From: Jonathan Best <Jonathan.Best@arun.gov.uk>
Sent: 14 August 2026 15:23
To: Planning.Responses <Planning.Responses@arun.gov.uk>
Cc: Hannah Kersley <Hannah.Kersley@arun.gov.uk>
Subject: LU/173/26/OUT

Westholme Nursery Toddington Lane Littlehampton BN17 7PP.

I have reviewed this application with regards to ecology and Biodiversity Net Gain.

Figure 3: Baseline habitats

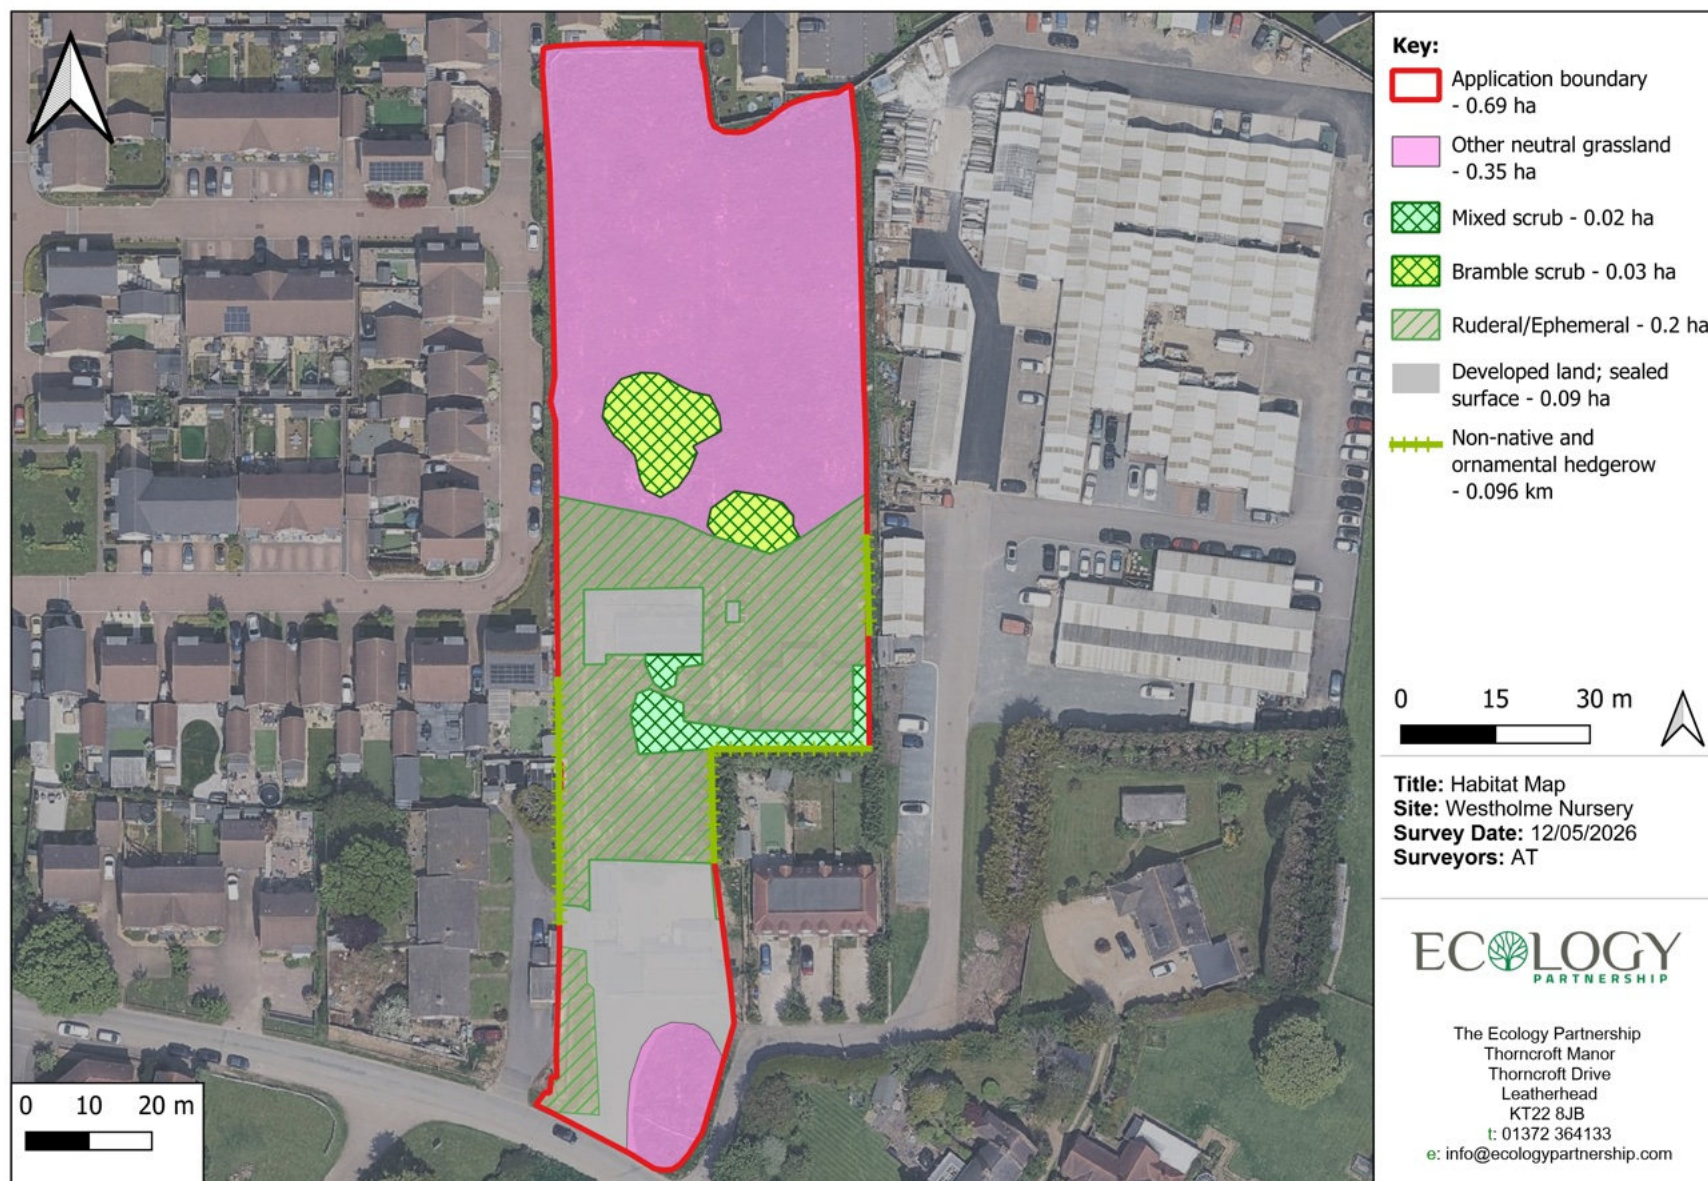
The Biodiversity Net Gain (BNG) Assessment by the Ecology Partnership dated May 2026. Shows a baseline habitat plan with ONG dominating the site and present post development in the north of the site. The metric states that no ONG is being retained but the assessment suggests that ONG will be created in the same place there is existing ONG. Clarity on what habitat will be retained and created this is sought. This can be addressed at reserved matters stage.

Figure 5: Headline Results

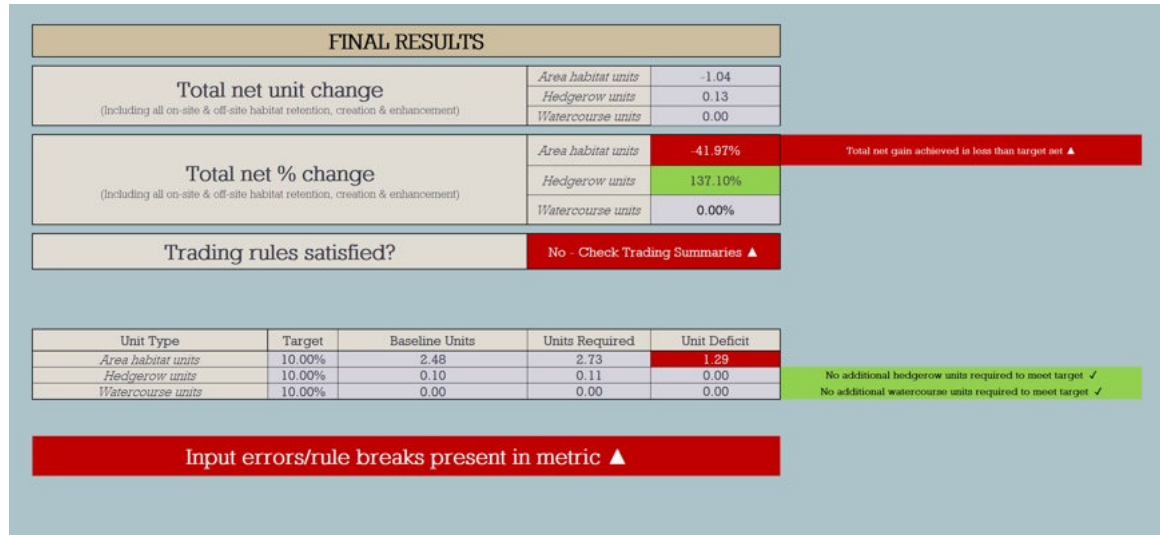
The BNG report and Statutory Metric shows a loss of 41.97% in habitat units. Provision of Offsite BNG units is required.
